# CITY OF ALBUQUERQUE

May 4, 2022

**Re: Stripes Burrito Co.  
Address  
Traffic Circulation Layout  
Architect's Stamp 04-18-2022 (H11-D073)**

Drawing file: H11D073 / H11D073_TCL_CMMT2.pdf

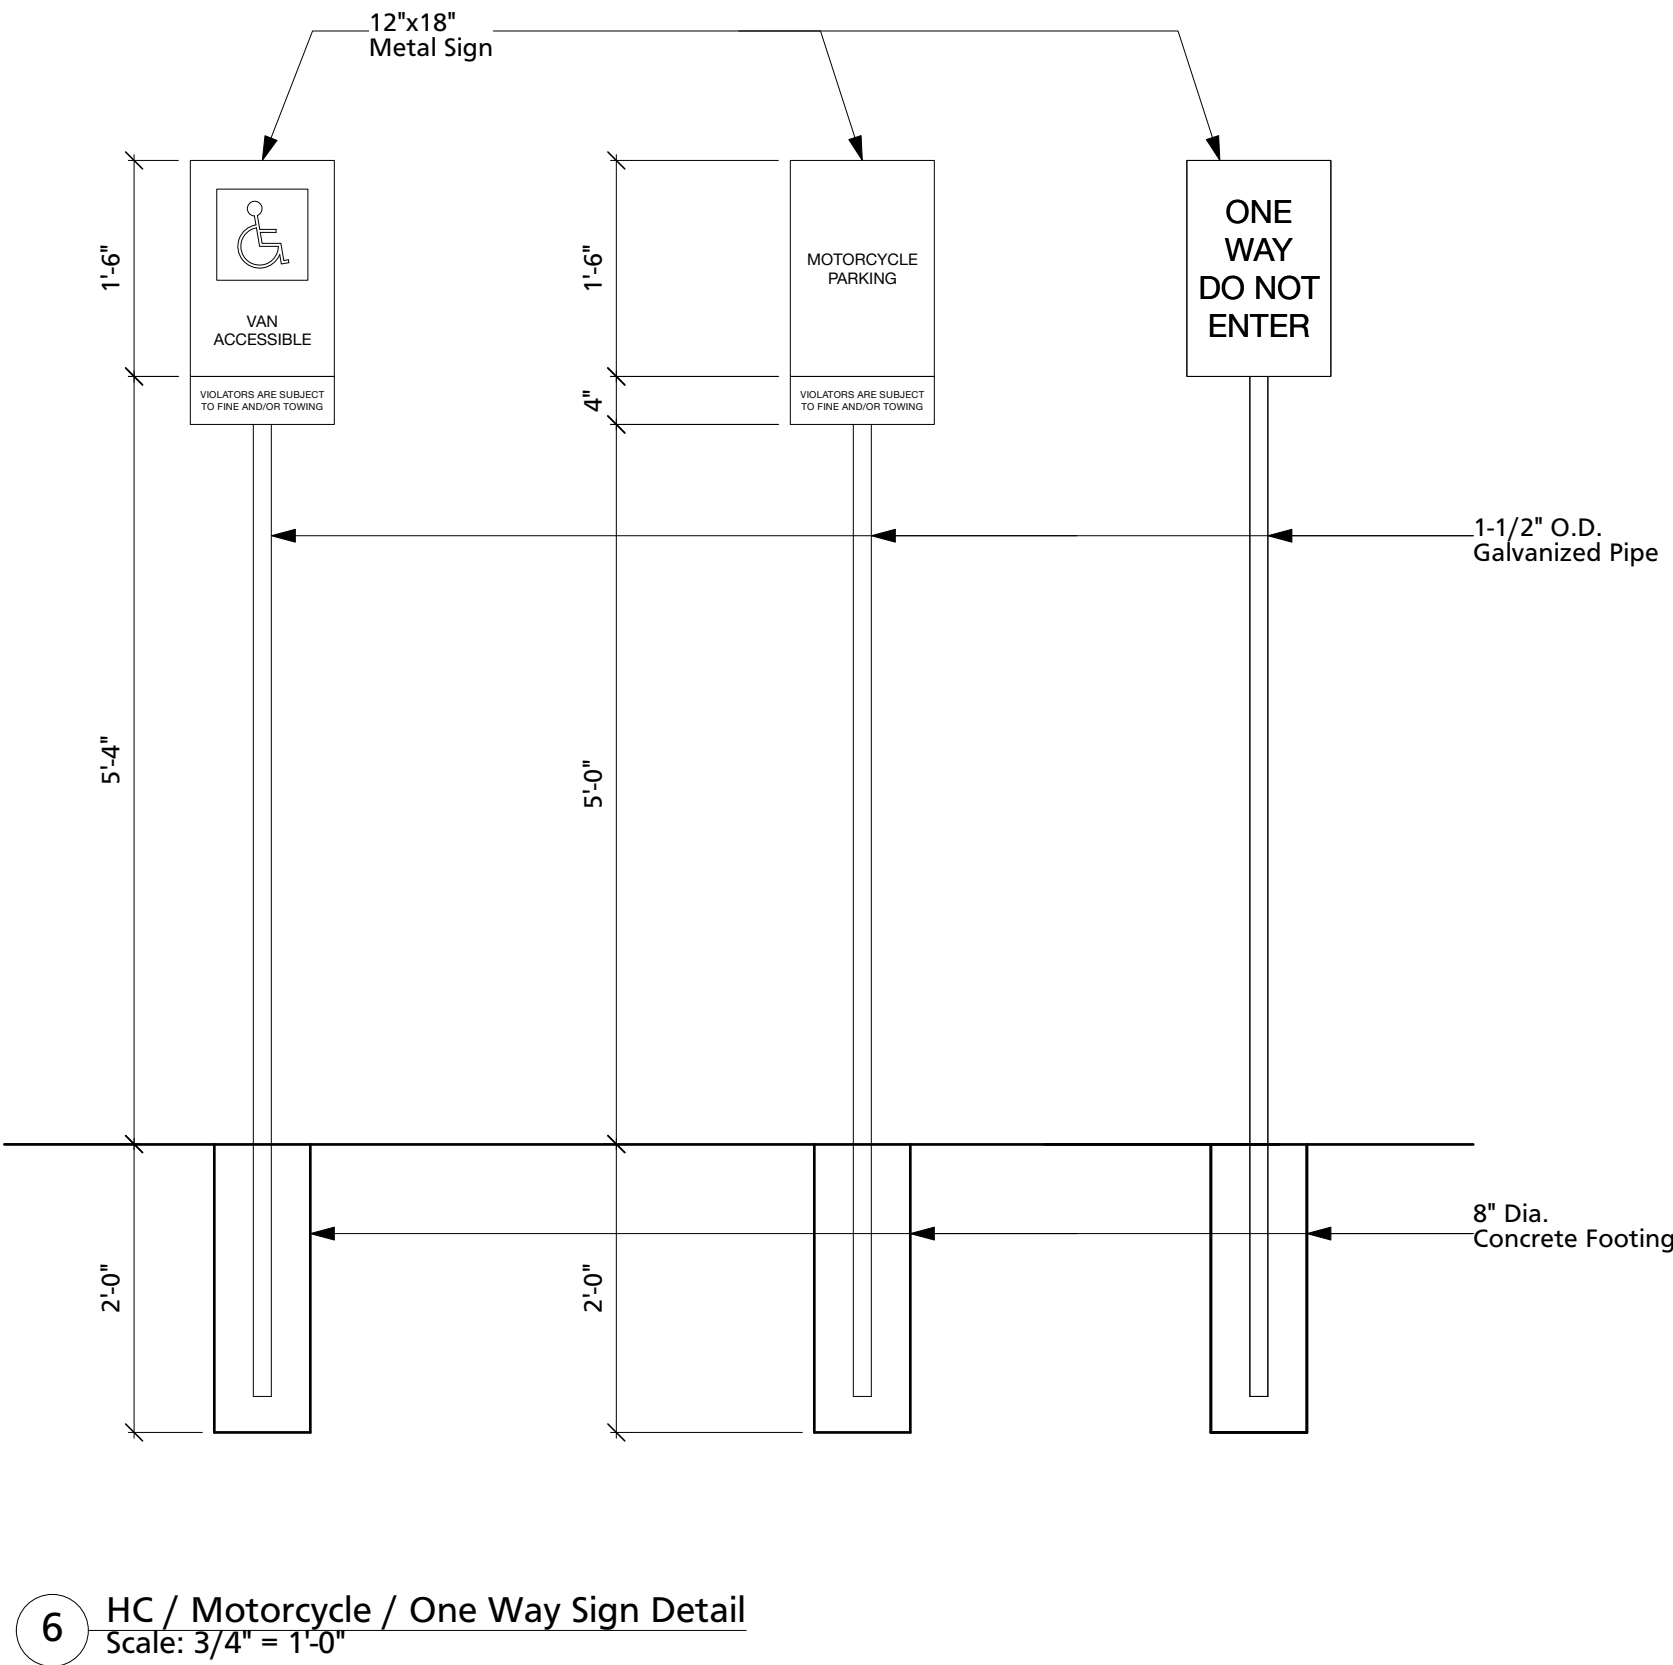
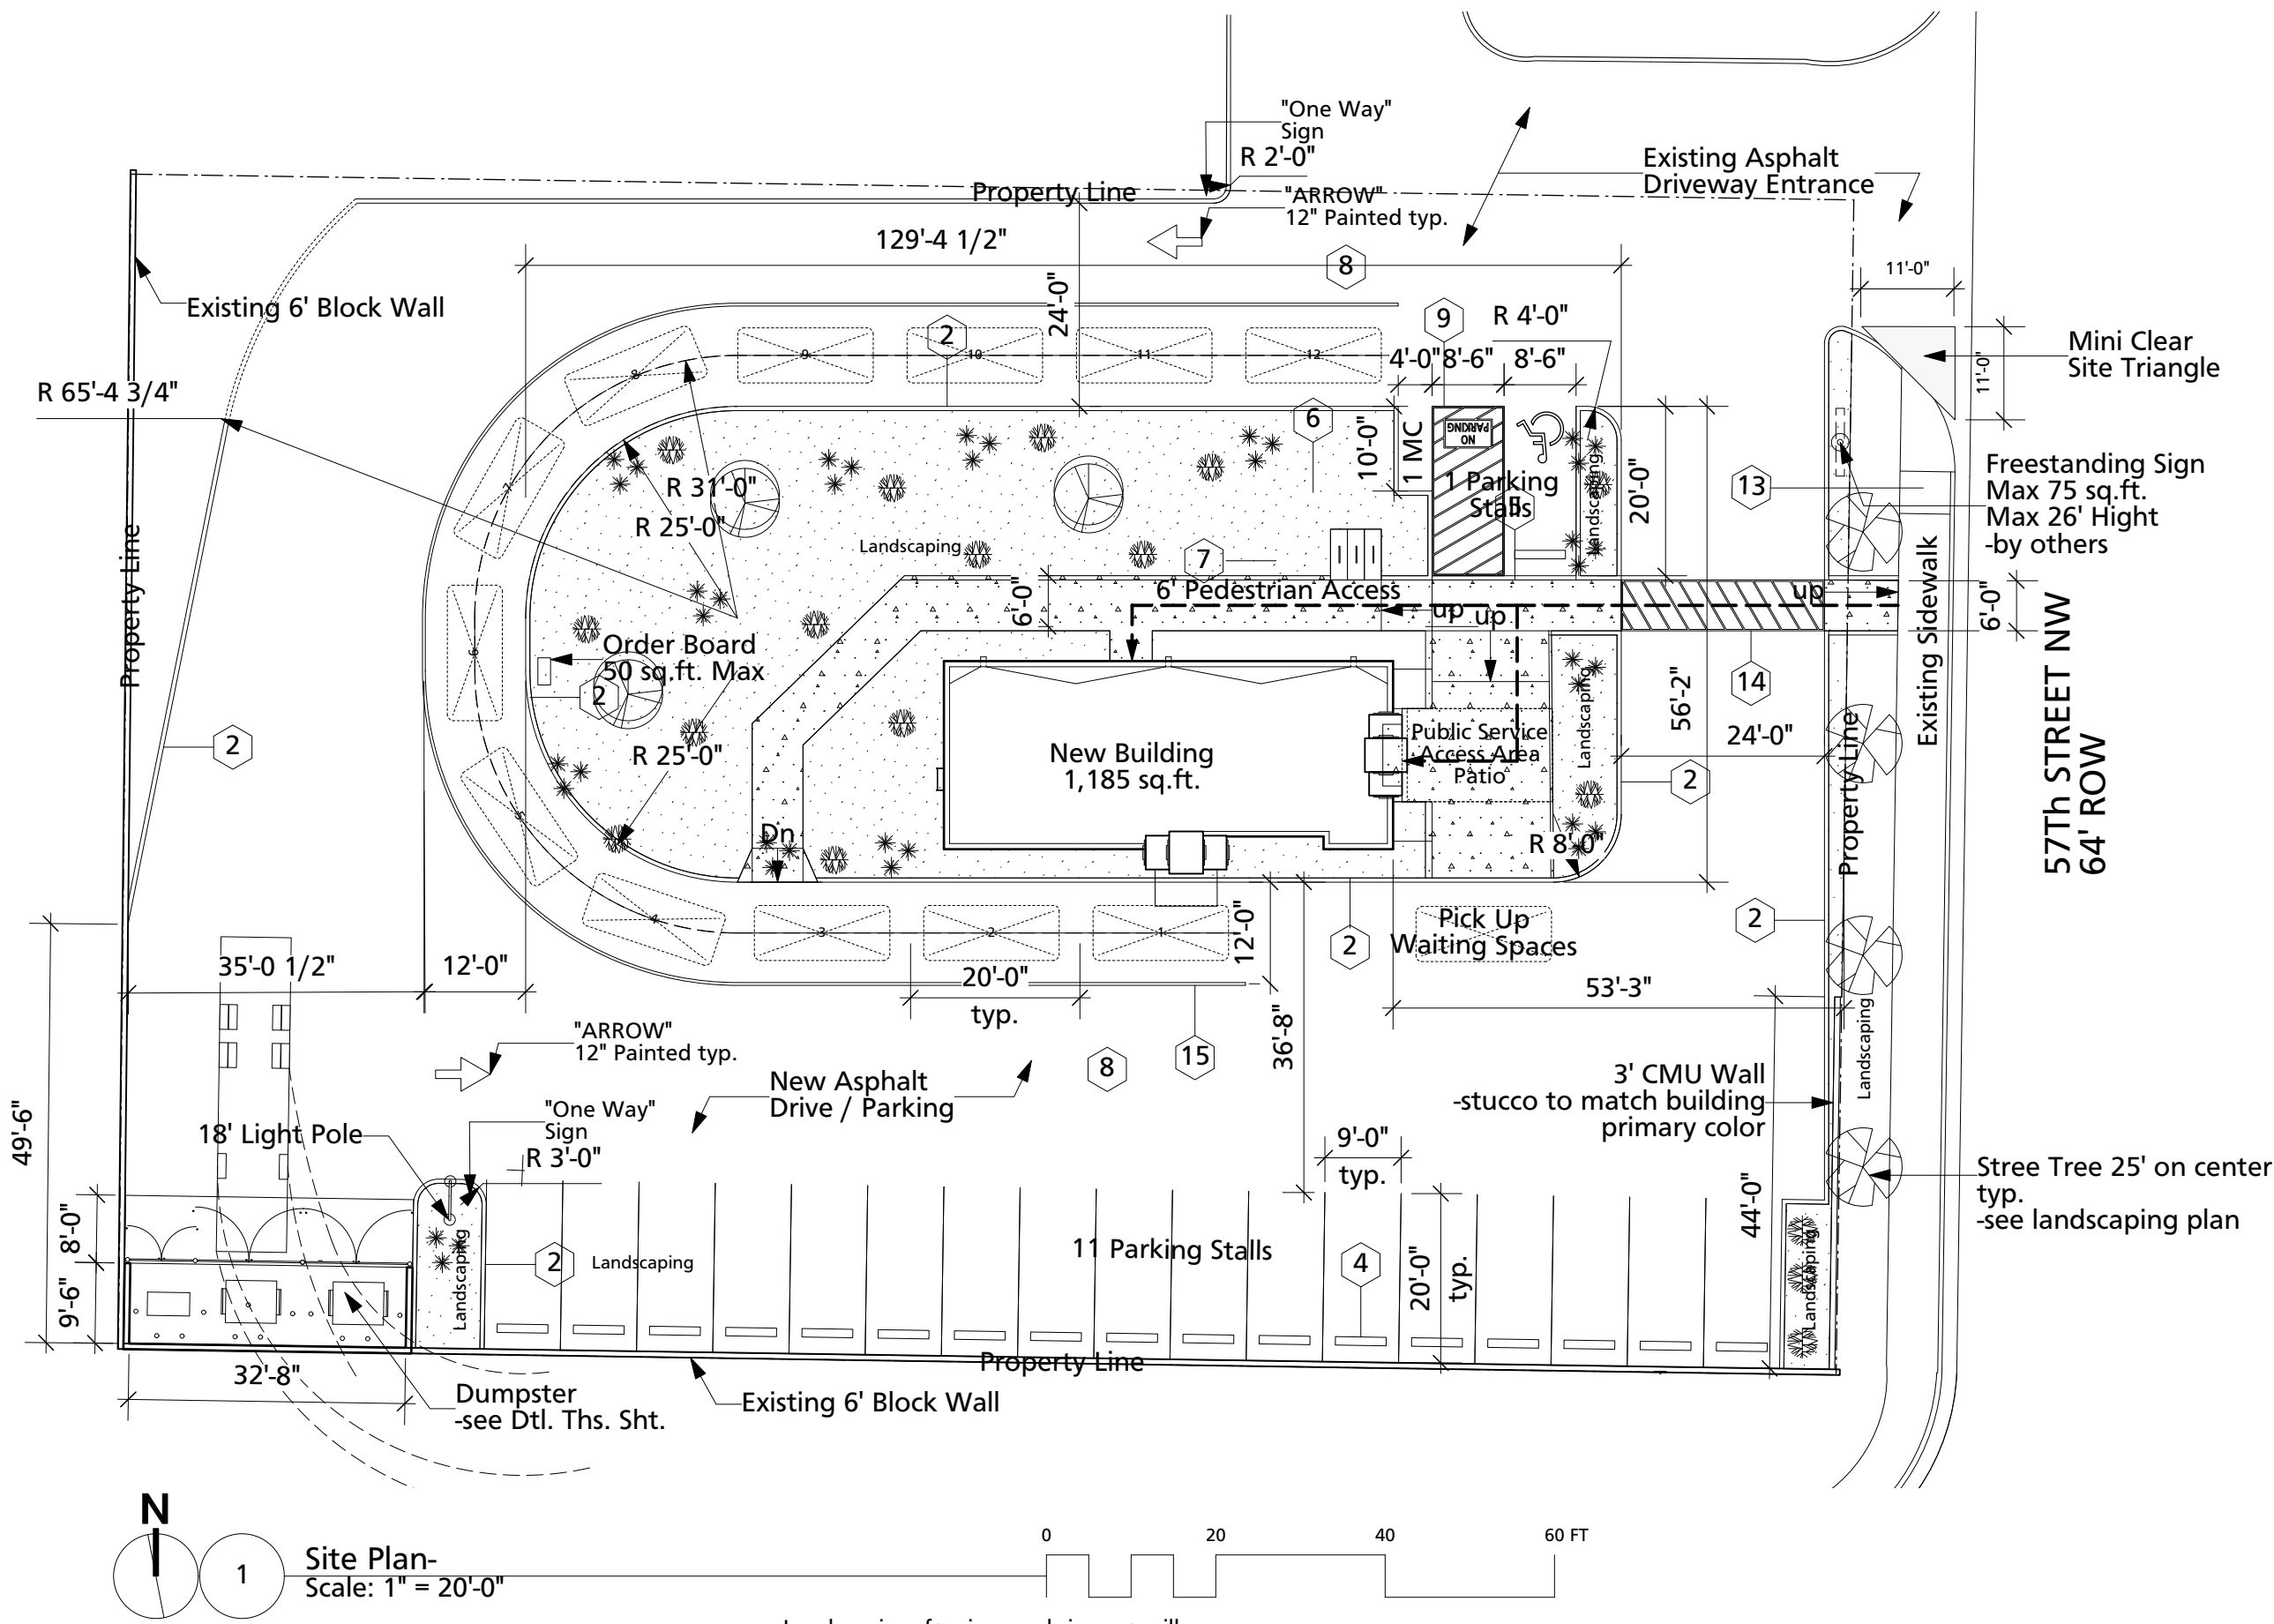
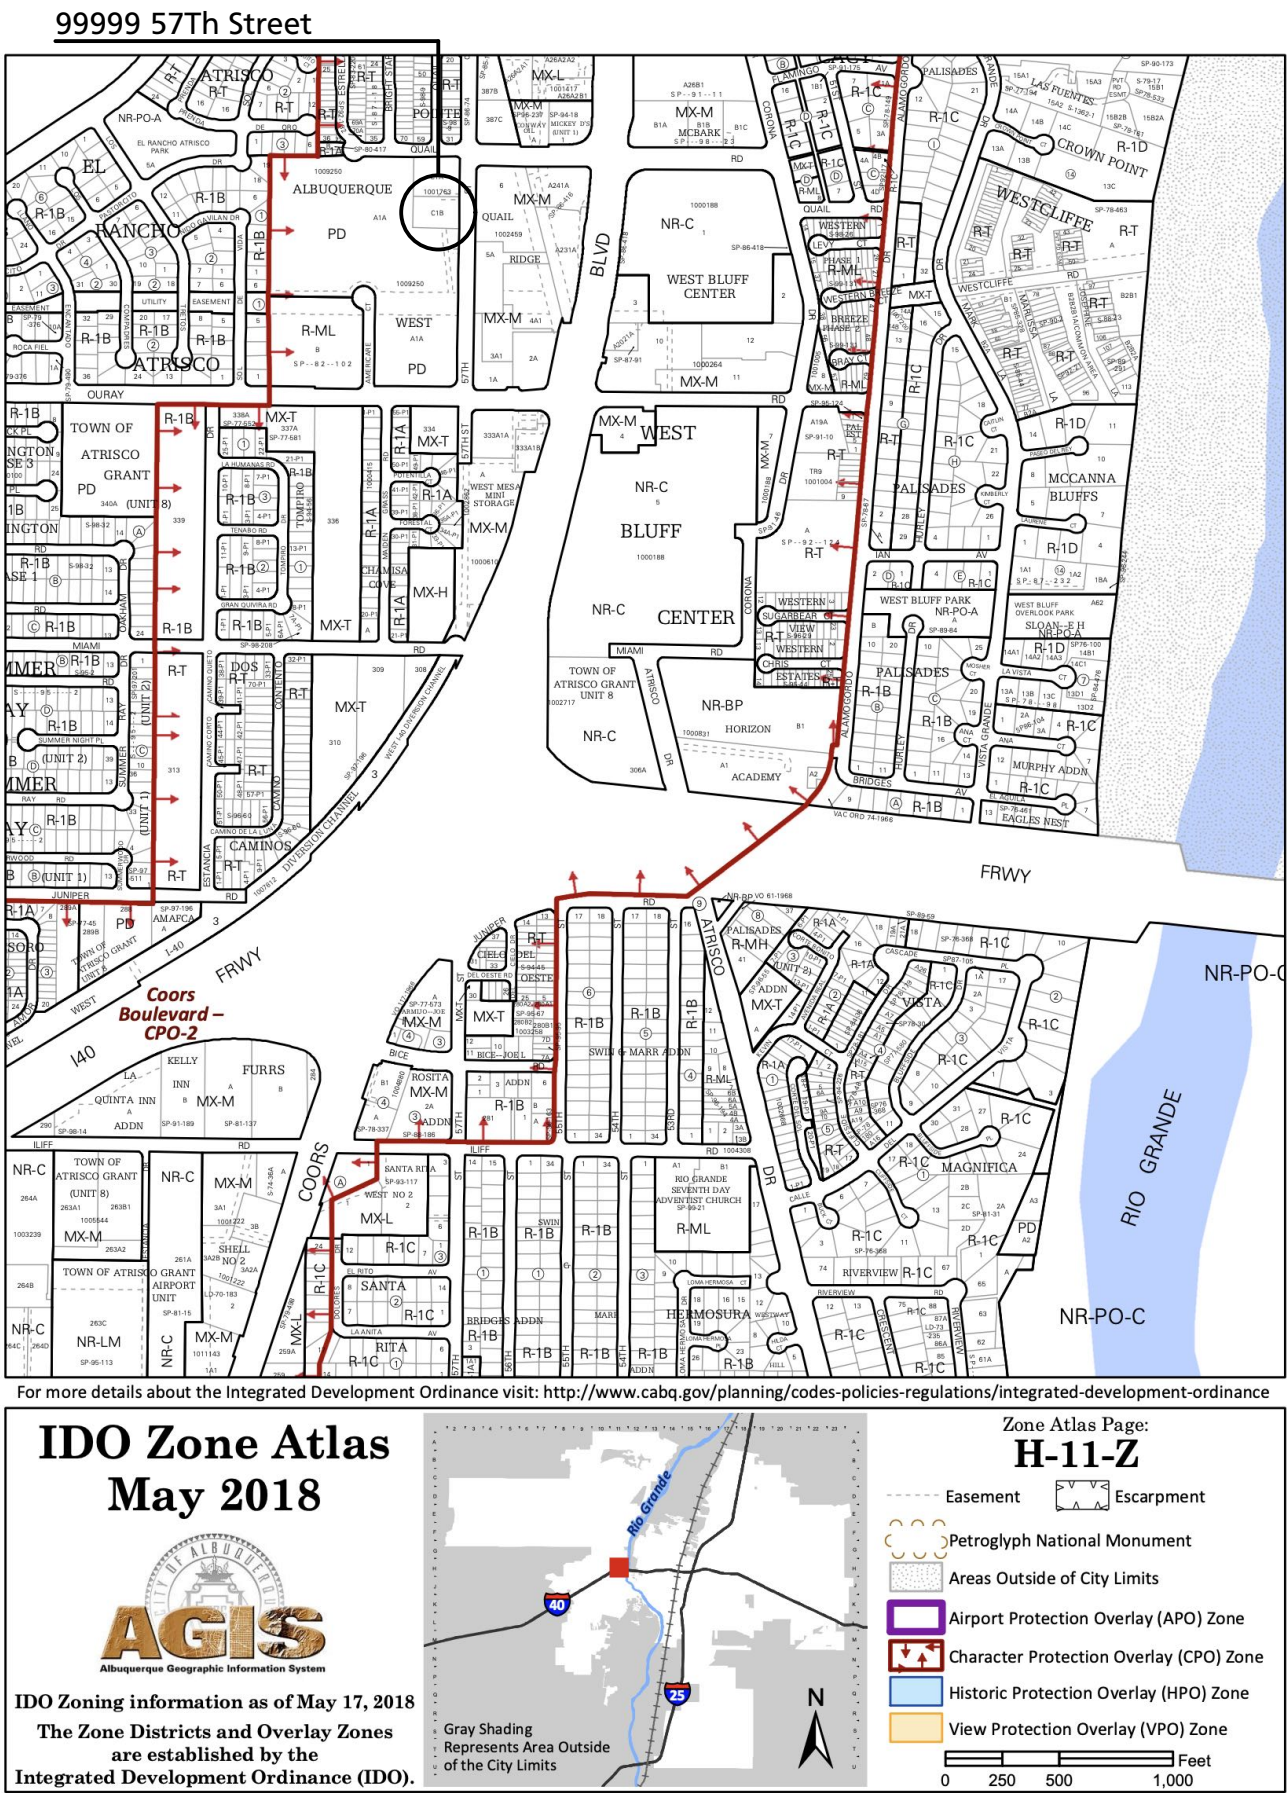
1. Listed are the number of parking spaces required by the IDO as well as the proposed number of parking spaces including bicycle and motorcycle parking.

**Coordinate/discuss with Zoning.**
2. Provide a street of the proposed Stripes Burritos Development.
3. **Queue length:**
  - Provide a queuing calculations to ensure it doesn't back into the entrance and 57<sup>th</sup> Street.

- What is the total vehicular queue length of the proposed drive thru shown on site plan? Will the queue land interfere with the parking? Explain?
4. The propose Freestanding Sign will need to be locate outside of COA ROW on private property (which includes **AIRSPACE**).

5. Please list the width and length for all proposed parking spaces and drive aisle. Some dimensions are not shown.
6. ADA curb ramps must be updated to current standards and have truncated domes installed at existing entrance off 57<sup>th</sup> Street NW. If not, then provide a new design to include truncated domes.

7. Internal ramps:
  - Will need details for the 6ft proposed pedestrian pathway from public sidewalk across drive aisle.
  - Shown is another ramp directly onto the drive thru lane Why? This is a safety concern for any patrons. Detail for this ramp will be needed was well.

- Do you need a ramp off ADA access aisle? Explain?
8. Show all drive aisle widths and radii. Some dimensions are not shown.
9. The minimum drive aisle dimensions are shown below

10. List radii for all curves shown. The minimum radius for internal is 15 ft. except the drive thru exit radius.
11. Per the DPM, a 6 ft. wide ADA accessible pedestrian pathway is required from the public sidewalk to the building entrances. Please clearly show this pathway and provide details. **Dimension proposed pathway.**

12. Per DPM, a 6 ft. wide ADA accessible pedestrian pathway is required from the ADA parking stall access aisles to the building entrances. Please clearly show this pathway and provide details.

13. All one-way drives shall have "One Way" and "Do Not Enter" signage and pavement markings. Please **show detail and location of posted signs and striping.**

14. Provide all pavement marking details of all proposed striping and pavement marking texts. This includes the striping around the parameter of the proposed drive thru lane.

15. The minimum drive through lane width is 12 feet with a 25 foot minimum radius (inside edge) for all turns. (A 15 foot radius can be used with an increase in lane width to 14 feet). Please dimension all lane widths and radii.

16. Keyed Note 2: Why are you proposing a 8 inch curb and gutter? when 6 inch curb and gutter is used for on site development.
17. Provide construction notes and details for proposed internal curbing around New building and landscaping.

18. Please provide a sight distance exhibit
19. Show the clear sight triangle and add the following note to the plan: "Landscaping and signage will not interfere with clear sight requirements. Therefore, signs, walls, trees, and shrubbery between 3 and 8 feet tall (as measured from the gutter pan) will not be acceptable in the clear sight triangle.

20. Shared Site access: driveways that straddle property lines, or are entirely on one property but are to be used by another property, shall have an access easement. Please include a copy of your shared access agreement with the adjacent property owner.

21. Add a note stating "All broken or cracked sidewalk must be replaced with sidewalk and curb & gutter." A build note must be provided referring to the appropriate City Standard drawing (2430 & 2415A).
